WEST SUSSEX COUNTY COUNCIL CONSULTATION

TO:	Arun District Council FAO: Simon Davies
FROM:	WSCC - Highways Authority
DATE:	7 April 2022
LOCATION:	36 Carlton Avenue Bognor Regis PO21 3LR
SUBJECT:	AW/47/22/DOC Approval of details reserved by condition imposed under AW/130/18/OUT relating to condition 8-Construction Environmental Management Plan. More information received.
DATE OF SITE VISIT:	n/a
RECOMMENDATION:	Advice
S106 CONTRIBUTION TOTAL:	n/a

Construction Environmant Management Plan (CEMP) at 1 : 5 0 0 s c a l e

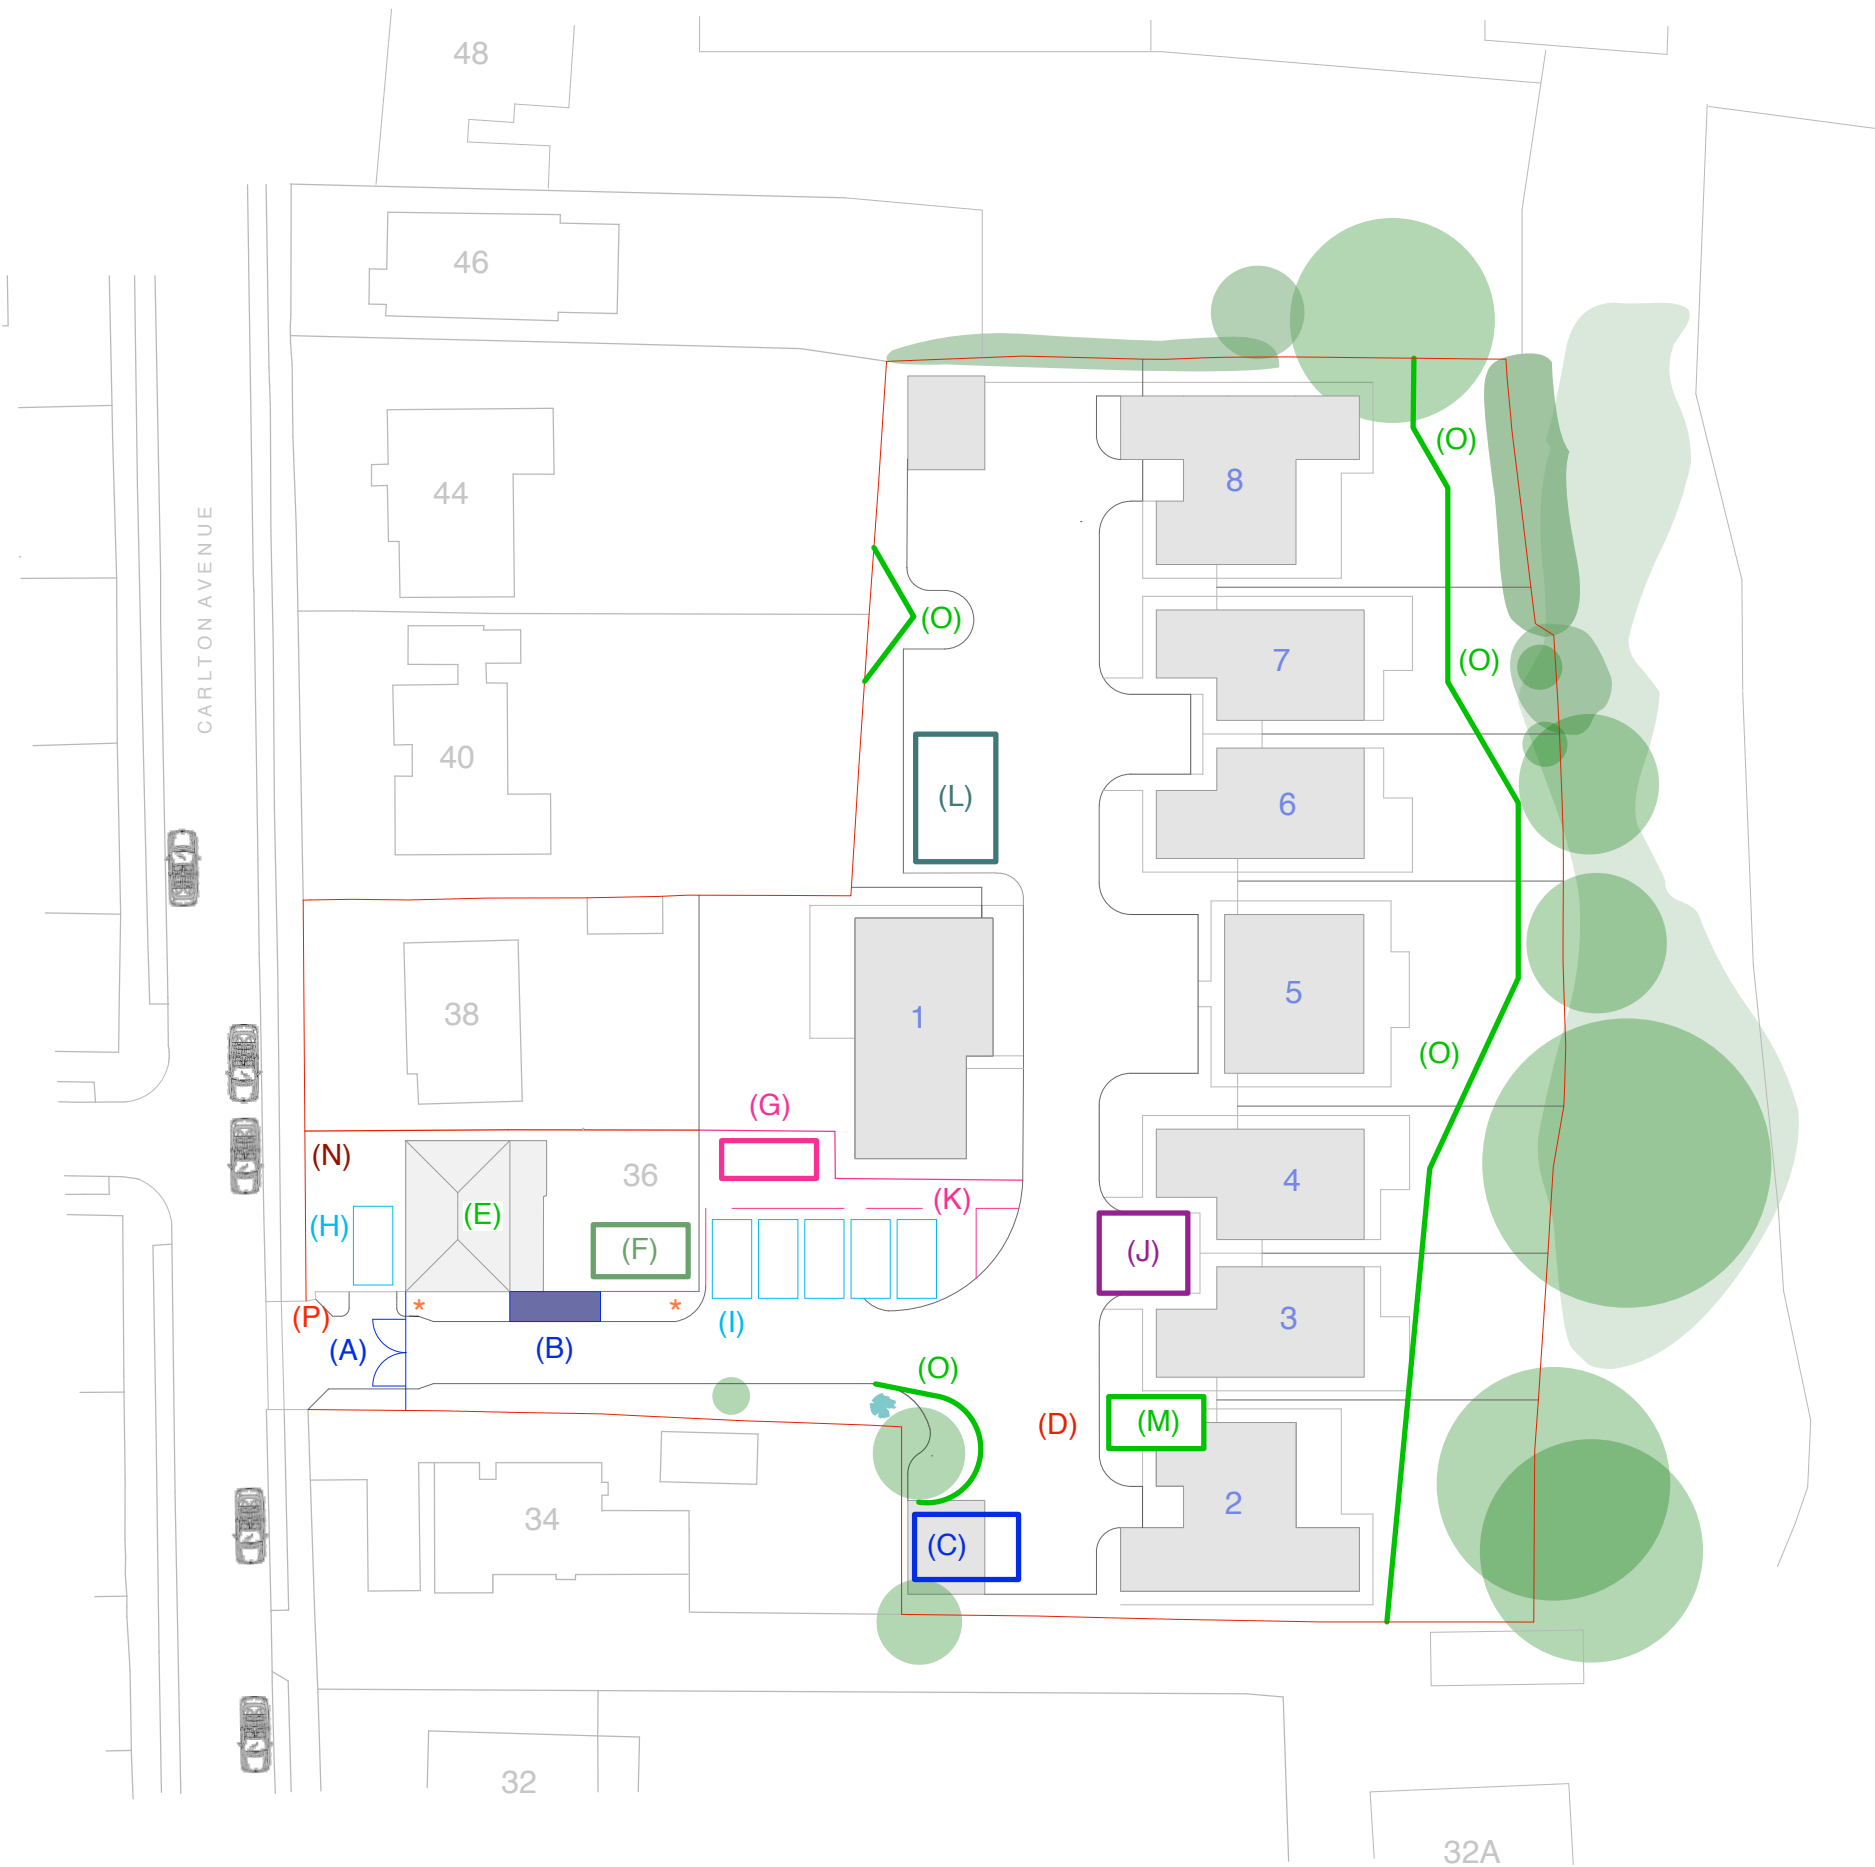
The applicany has provided and amended CEMP which now included; deliveries outside of school hours only, a Banksman and pedestrian visibility splays.

No highway objection.
